Our ref: 20044454
Your ref: TR020005
Date: 5 June 2024

Gatwick Airport Northern Runway Development Consent Order Application - Environment Agency comment on Change 4: Provision of an on-airport Wastewater Treatment Works. Deadline 5, 6 June 2024

[Additional Footpath Route during construction of Water Treatment Works](#)

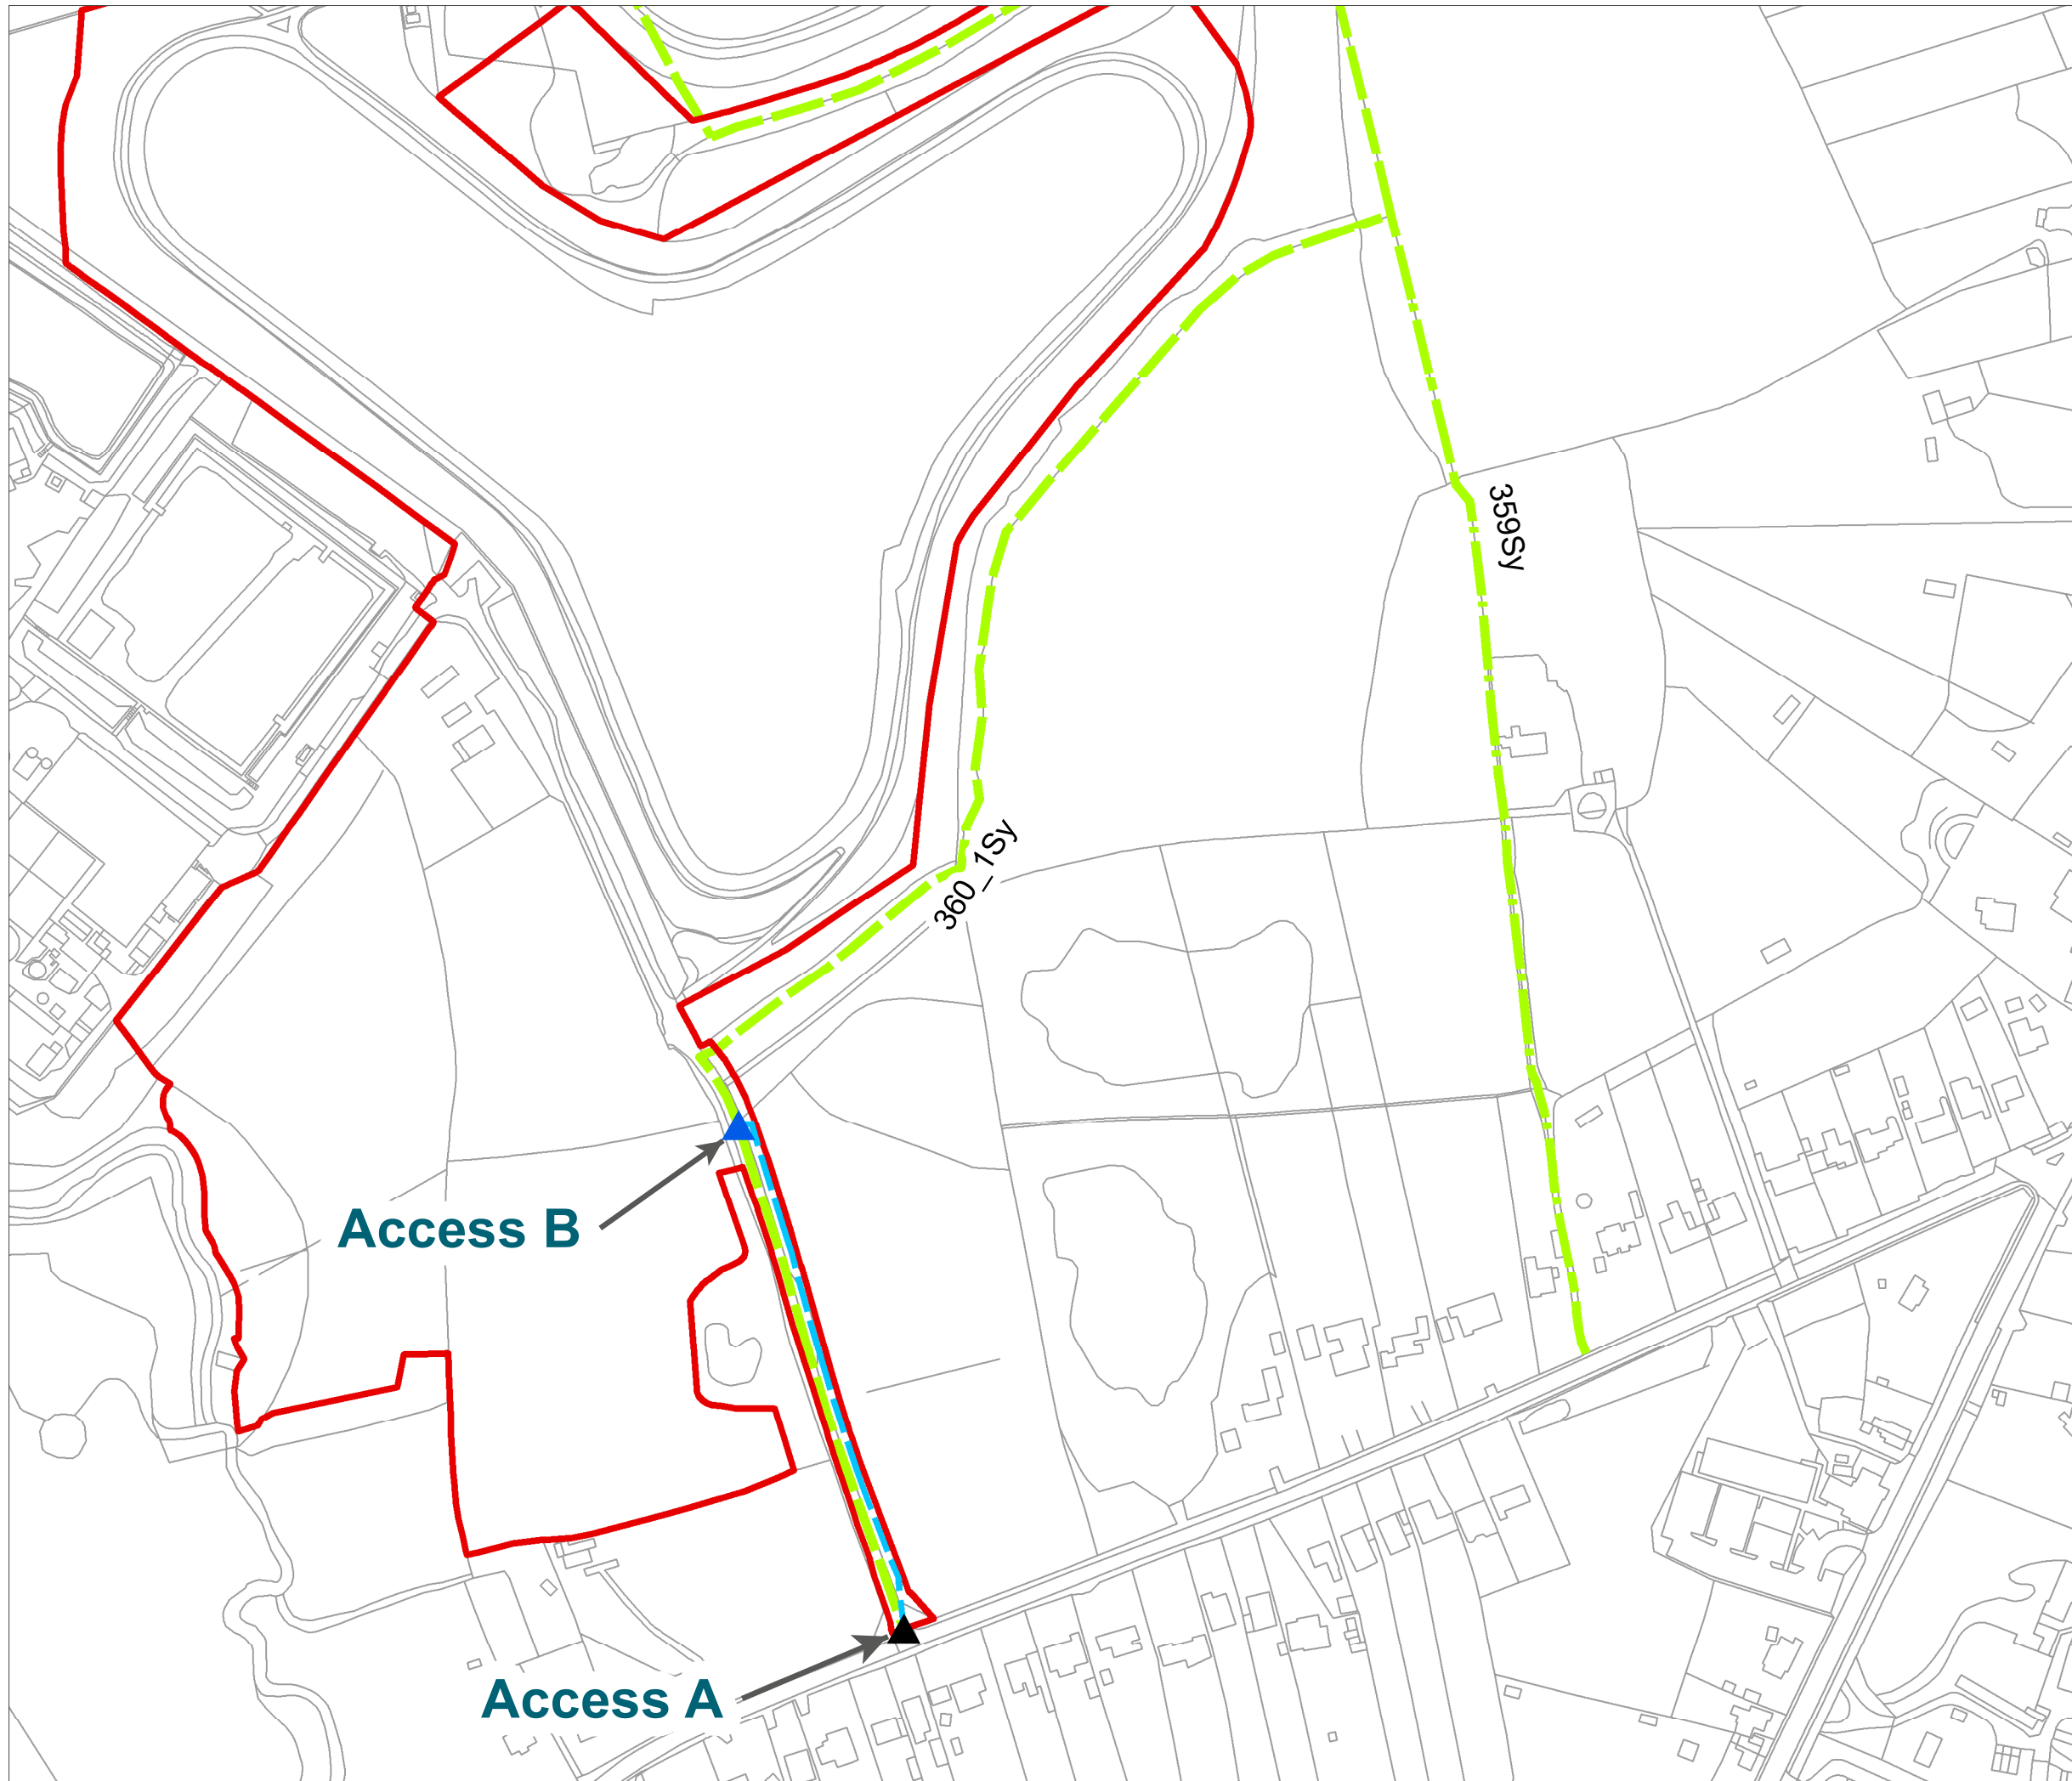
The information supplied regarding the potential new facility lacks detail. For example, flows, population equivalent. We have asked the applicant to confirm how has the planned layout been sized.

- The proposed WWTW facility is located outside of areas considered to be at risk to flooding
- The proposed WWTW facility would not lead to a loss of floodplain storage capacity or impact on flood flow routes
- The proposed WWTW would be designed to carry on functioning during a flood event? What Flood Risk Vulnerability Classification has been given to the proposed WWTW in line with Annex 3 of the National Planning Policy Framework, considering Table 2 of the Flood Risk & Coastal Change Planning Practice Guidance
- The temporary construction compounds will be located outside of areas considered to be at risk to flooding

The document states that they propose to use a directional drilling technique to install a new outfall into the River Mole to have a lesser impact on the flood defence. It should be noted that any works in, over, under or within 8 metres of the top of the bank of a main river, or within 8 metres of the landward toe of a flood defence would require assessment under the Environmental Permitting Regulations 2016 to understand whether a Flood Risk Activity Permit(s) would be required for the proposed WWTW.

Within the 'Second Notification of a Proposed Project Change' document (Book 10), it appears that the WWTW will be located outside of the fluvial flood risk areas according to modelling provided by Gatwick Airport Limited, but it would be helpful to see confirmation of this since it does appear the site is located within our Flood Map for Planning.
